Application No: FG/123/20/PL
Site Address: Land at former McIntyre Nursery Littlehampton Road Ferring BN12 6PG
Description of Works: Demolition of a polytunnel, storage building & scaffolders' shelters & racking, use of land for Class B8 container self-storage & the siting of 79 No. single-stacked storage containers, part regrading of the ground, new fencing, CCTV & lighting. This site is in CIL Zone 3 (Zero Rated) as other development & is a Departure from the Development Plan.

Liz Annalls
Environment Officer
Environmental Protection
Chichester District Council

STATUS	CLIENT		
Outline Design	Standby Self-Storage		
SCALES	DATE	SIZE	
1 : 200	Sept 2020	A2	
TITLE			
PROPOSED SITE & BLOCK PLAN			
DWG NO			REV
5320-2		d

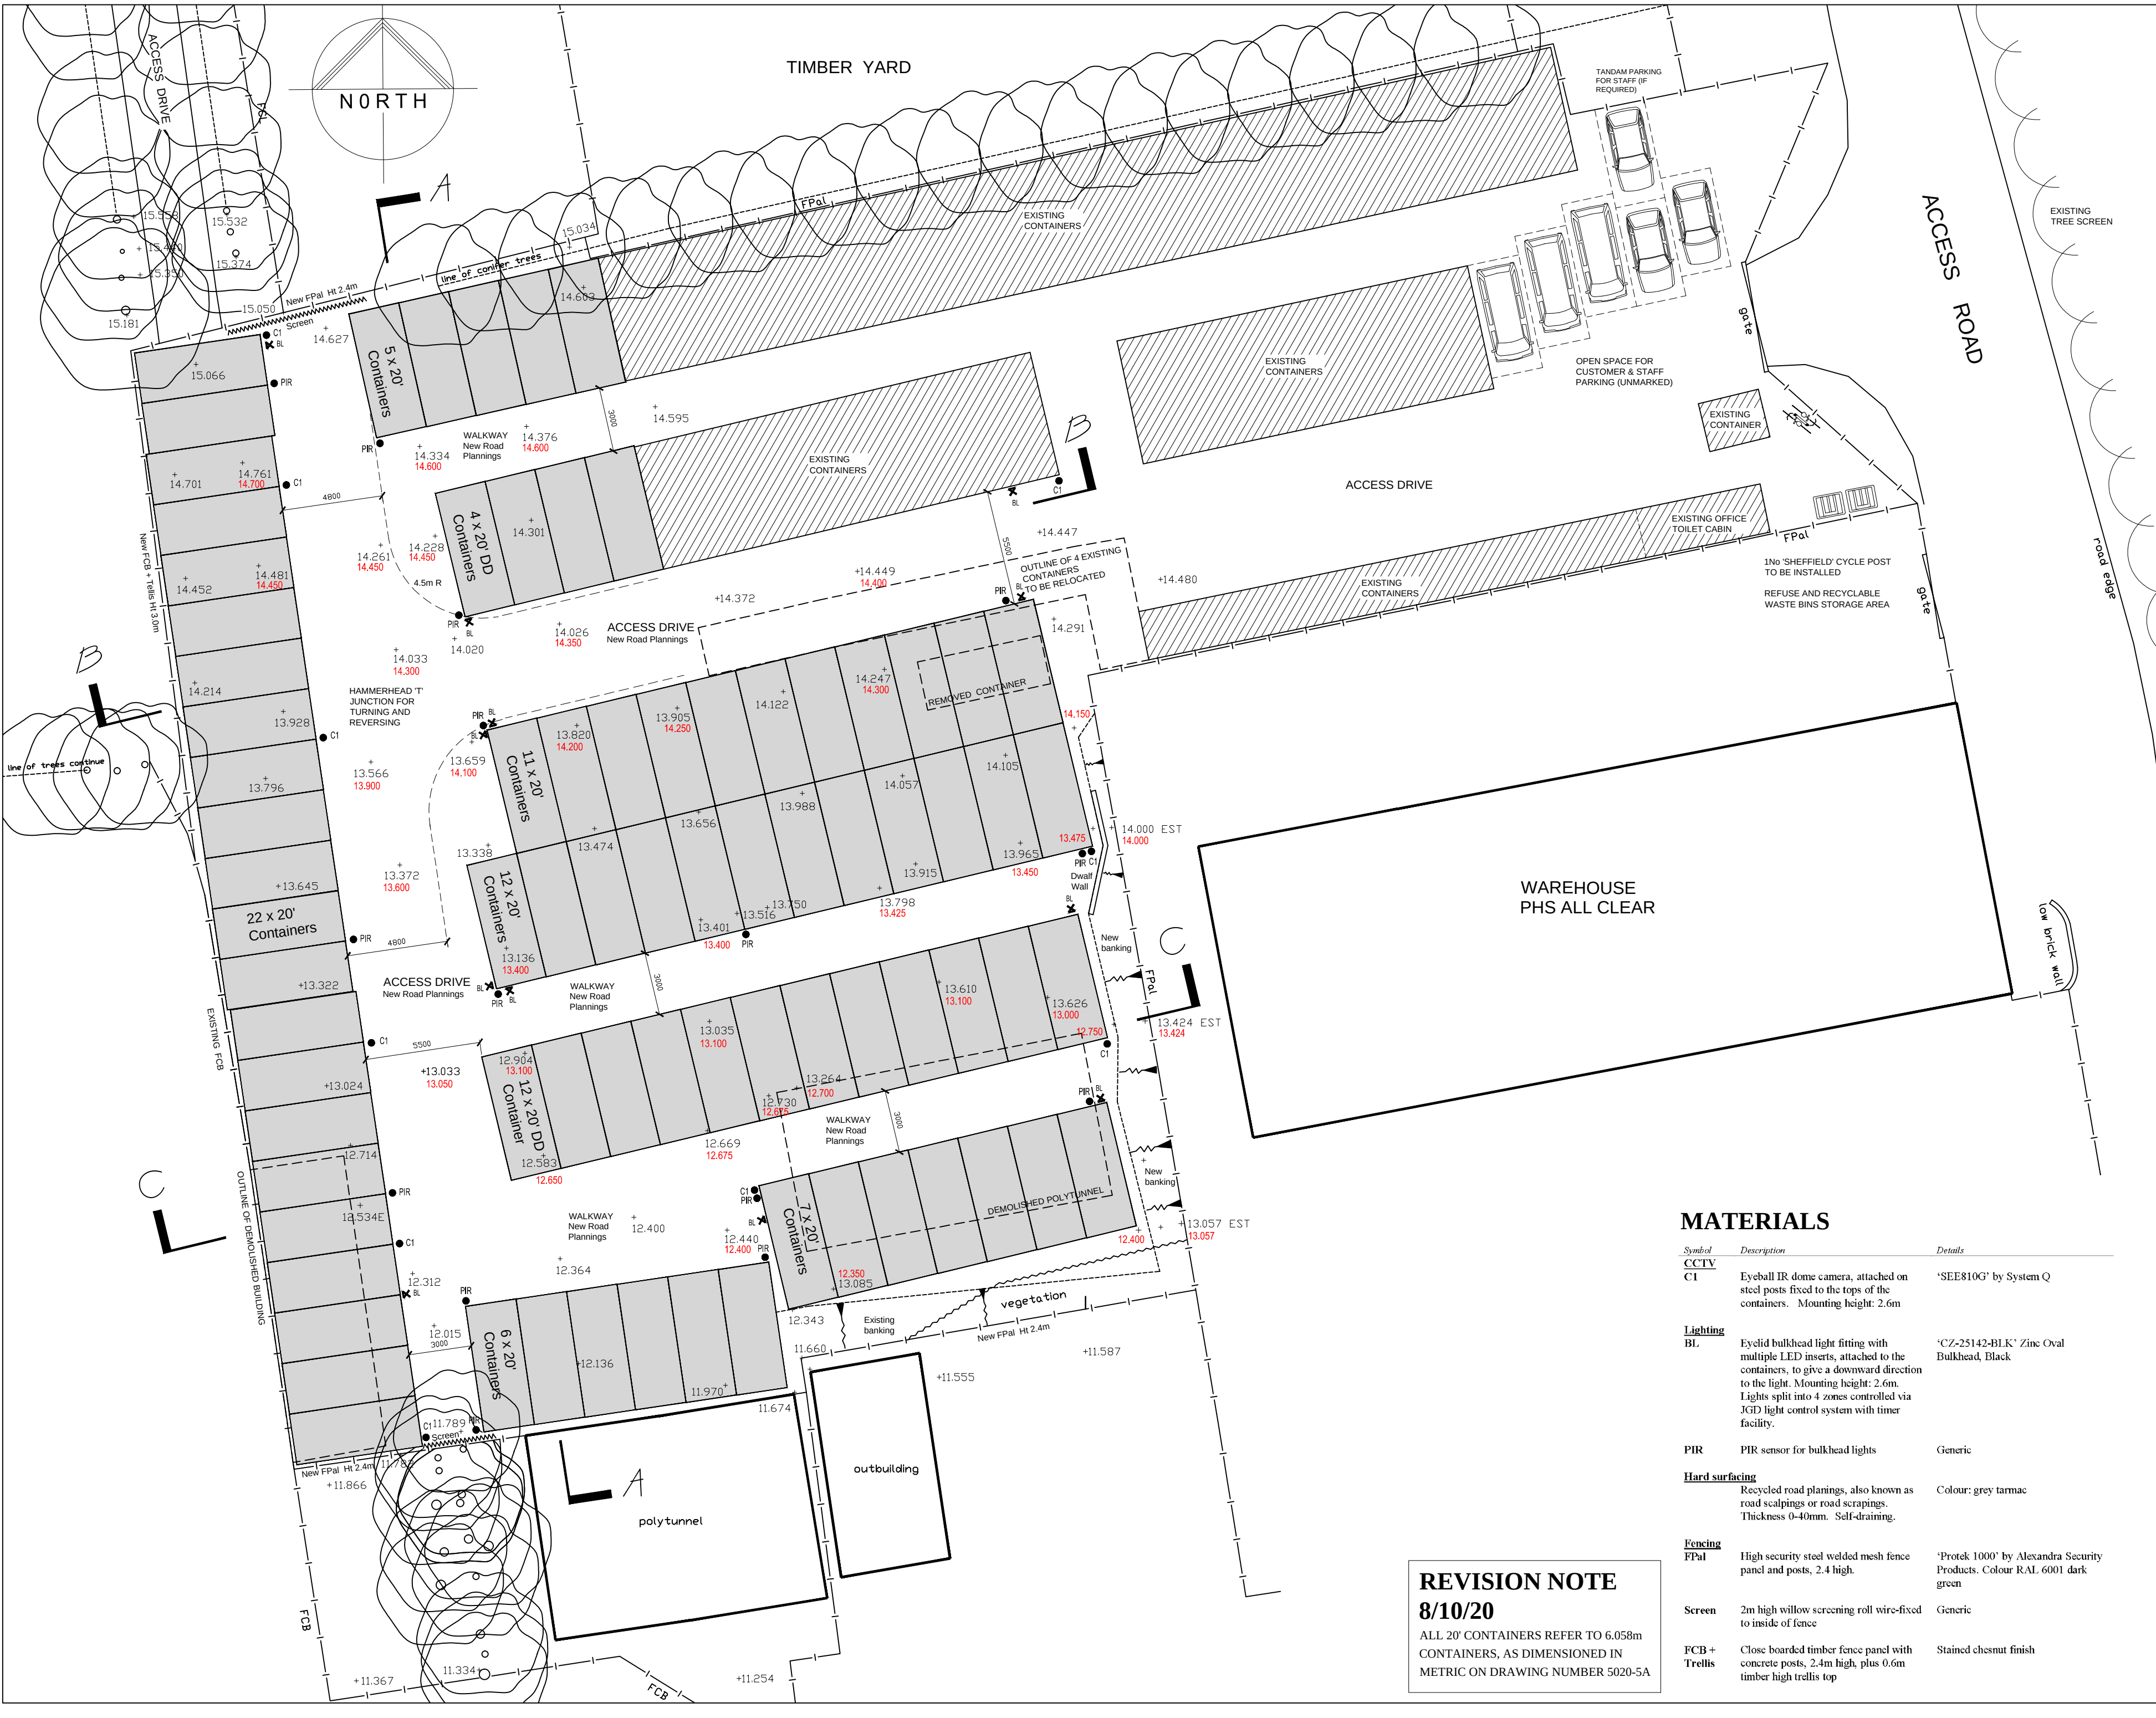
The lighting scheme for the site will need to take into consideration the presence of bats in the local area and the scheme should minimise potential impacts to any bats using the trees, hedgerows and buildings by avoiding unnecessary artificial light spill through the use of directional light sources and shielding.
